**Memo**

<b>To</b>	Ivanhoe A1	<b>Date</b>	09.01.2020
<b>From</b>	Bates Smart	<b>Project No</b>	S12067.A
<b>Project</b>	Ivanhoe A1		
<b>Subject</b>	Amendments since DA submission

Lower Ground Plan

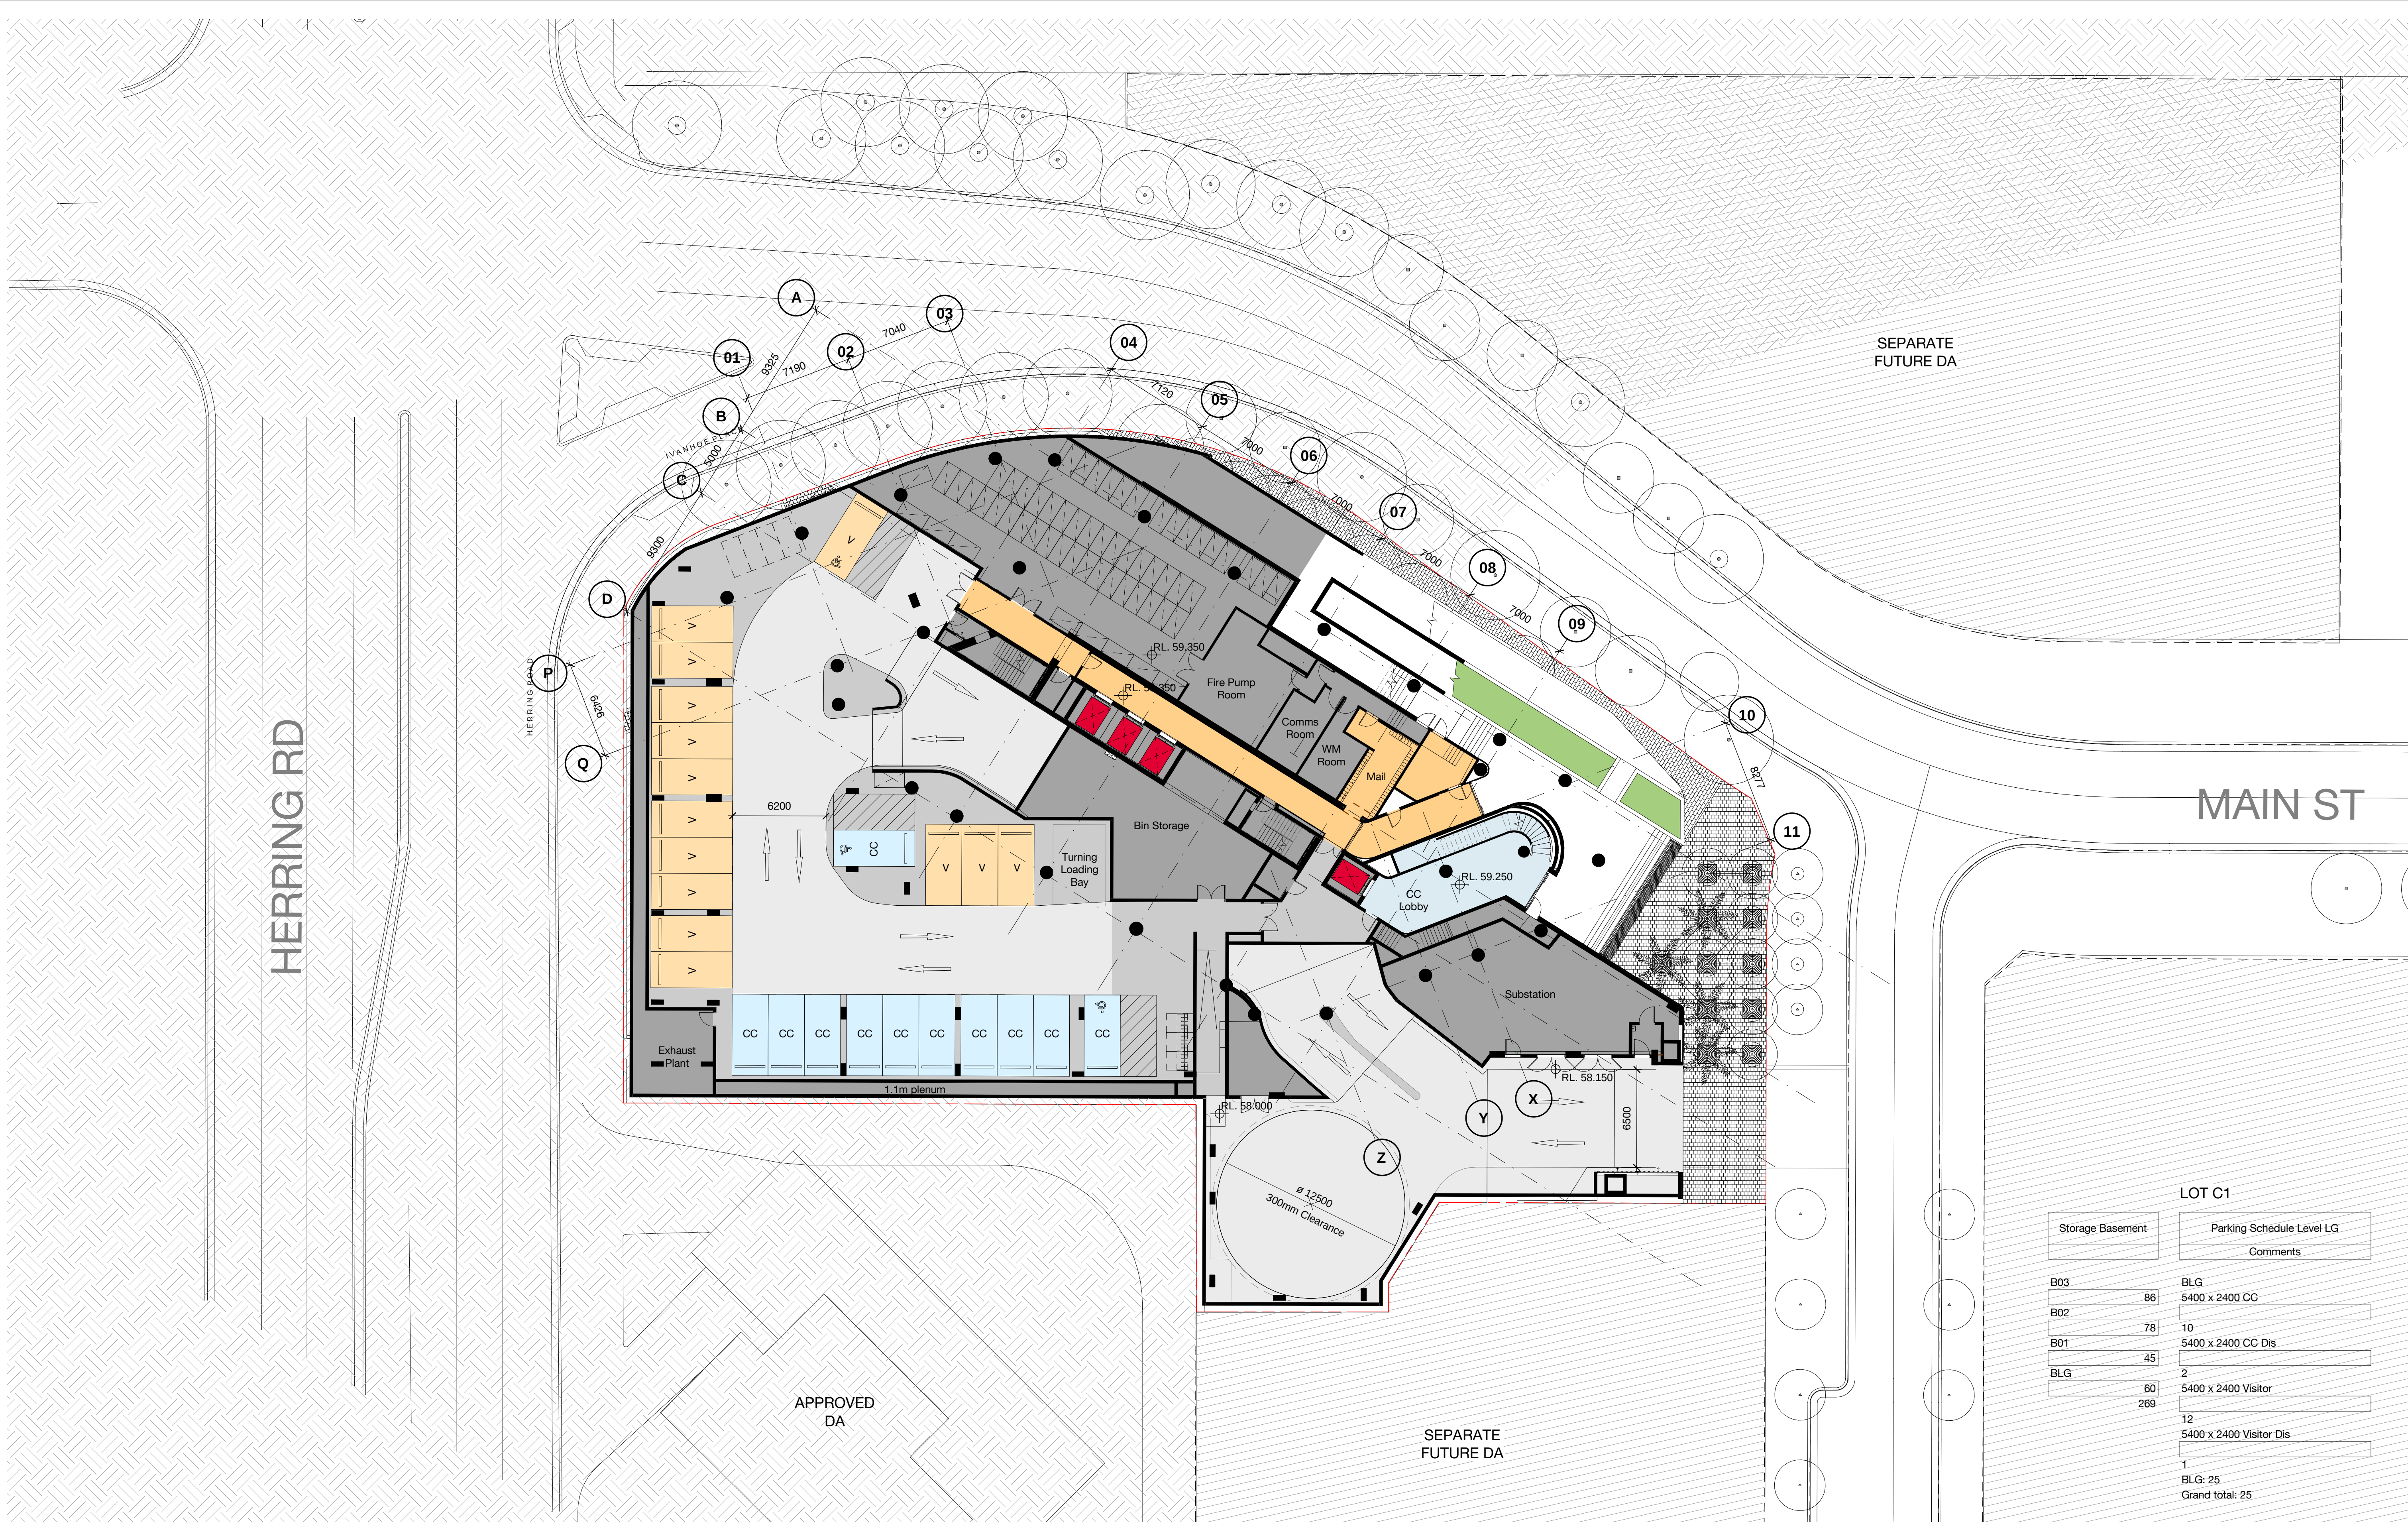
Amended residential and childcare centre lobby  
Residential storage room enlarged into deep excavation area  
Fire booster assembly relocated here  
Fire control room relocated here
